**Green Square Integrated  
Community Facility & School**  
3 Joynton Avenue  
Zetland NSW 2017

**ACCESSIBILITY  
REPORT**

**Our Ref:** AN020-215729  
**Date:** 23/07/2021

GA PLAN - GROUND LEVEL

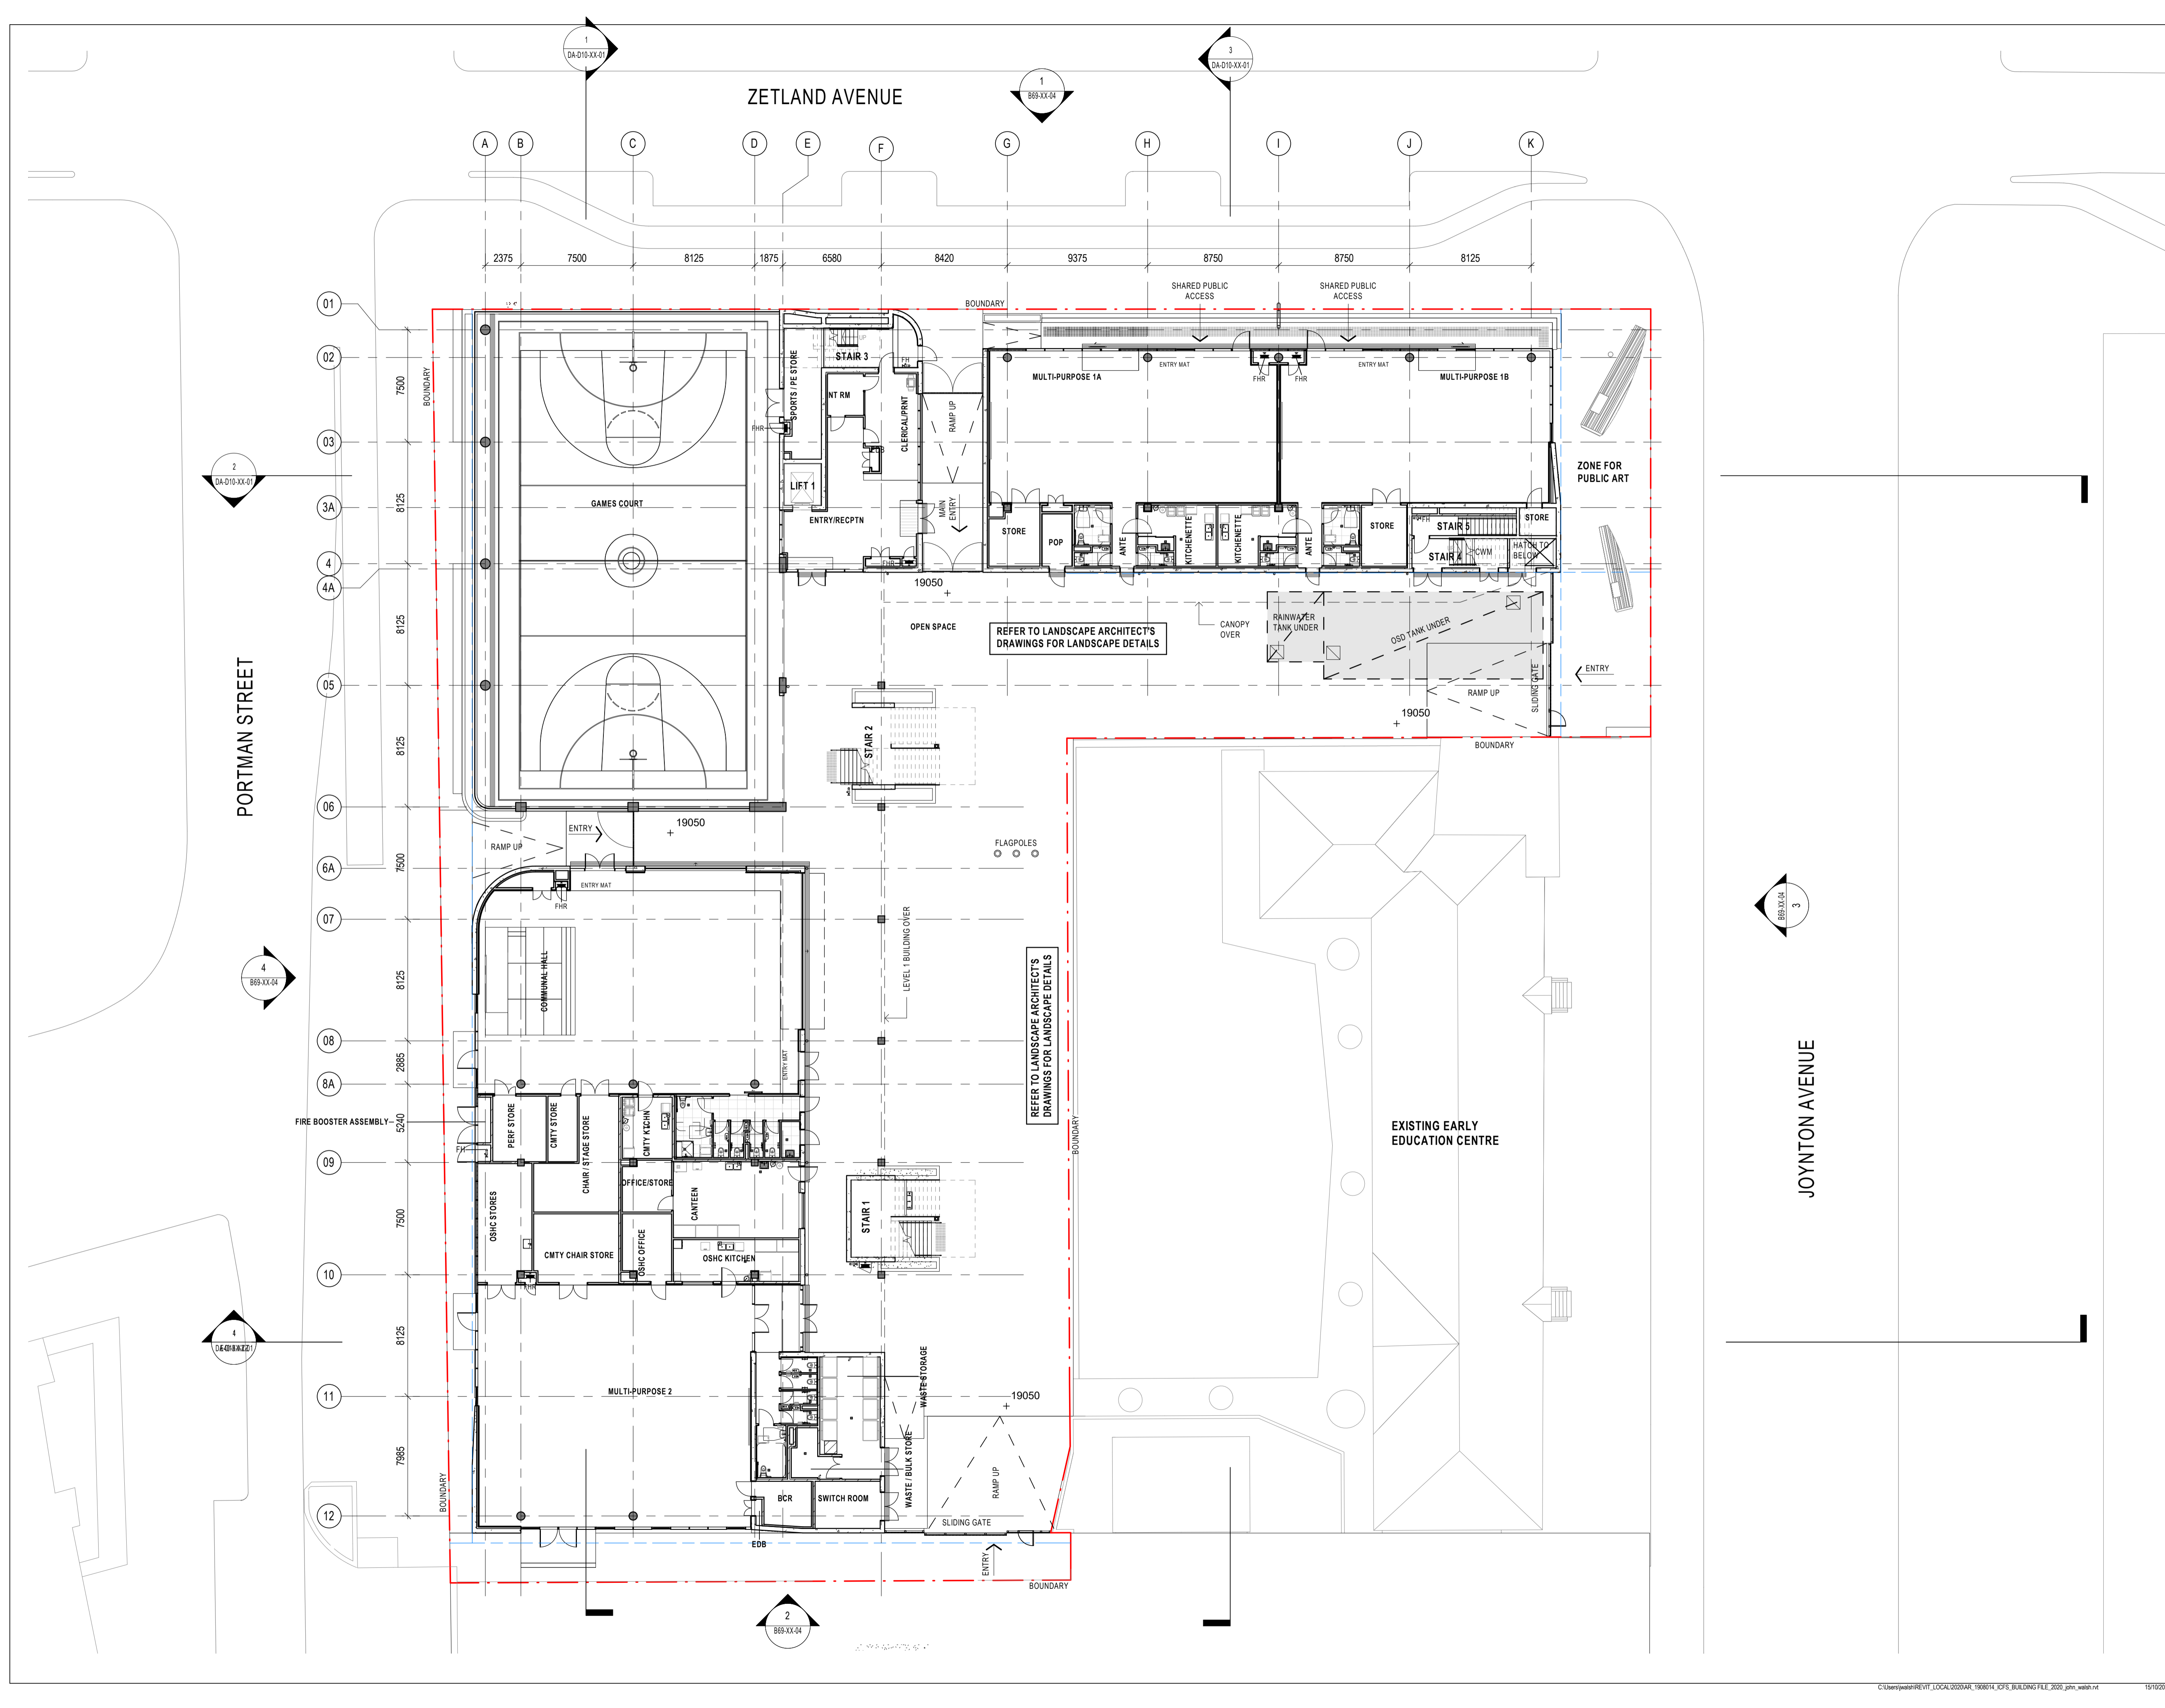
- a) There are multiple doorways along required accessways on ground floor, levels 1 and 3 of the new school building that can be increased in door circulation spaces for manual operation and/or that can be on power operation or automation for compliance with AS1428.1-2009 and to provide access to and within all areas in accordance with BCA D3.1.

- c) An additional performance based solution is possible and may be required for handrail set outs on the external domain on the ground floor along northern Zetland Avenue boundary outside Multipurpose 1A and 1B.

No	BCA Requirements	Status of Compliance	Discussion
<b>D3.3 Parts of Buildings to be Accessible</b>			
1.	Every ramp and stairway, except for ramps and stairways in areas exempted by D3.4, must comply AS 1428.1; as required.	<b>Can Comply</b>  <b>Possible Performance Based Solution</b>	<p>Complies in Principle.</p> <p>There appears to be multiple stairs and ramps outside areas exempt under BCA Clause D3.4 that are spatially capable of achieving compliance.</p> <p>An additional performance solution is possible and may be required for handrail set outs on the external domain on the ground floor along northern Zetland Avenue boundary outside Multipurpose 1A and 1B.</p>

GA PLAN - LEVEL 01

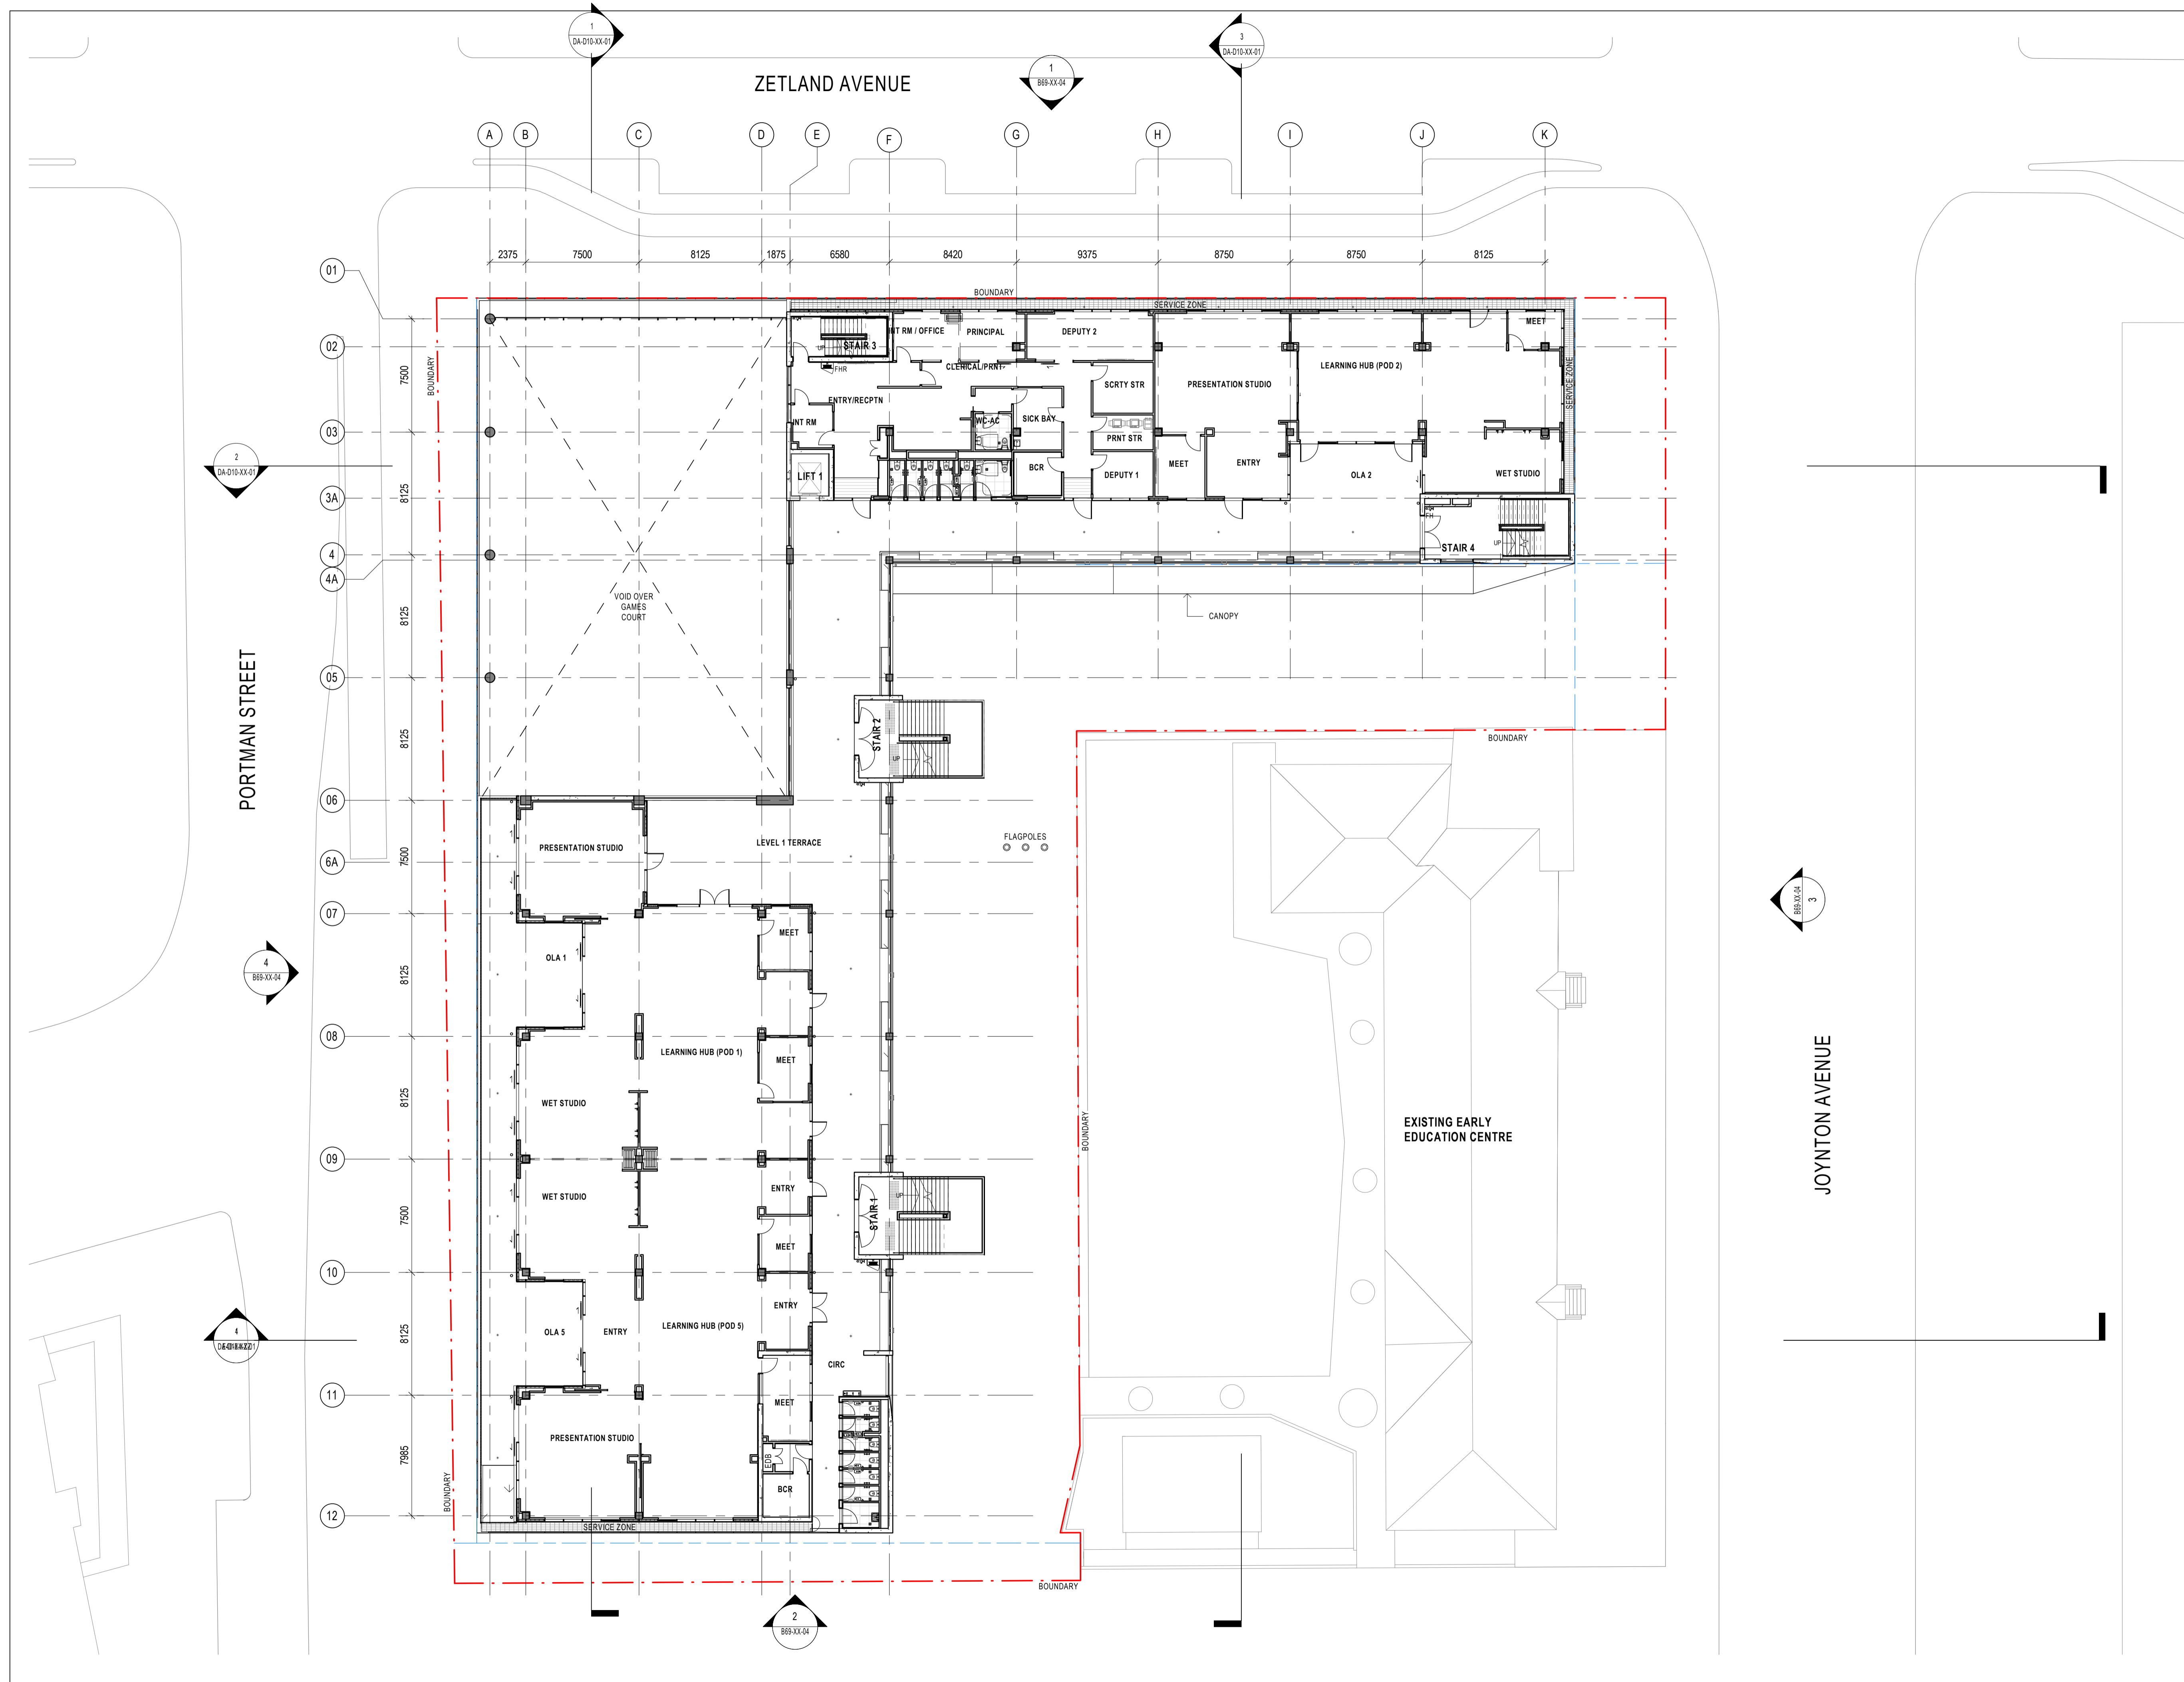
- e) There are two unisex accessible sanitary compartments provided on level 1 of the new school building that can be modified to achieve an even balance of Left Hand and Right-Hand Transfer toilet facilities in accordance with BCA F2.4.
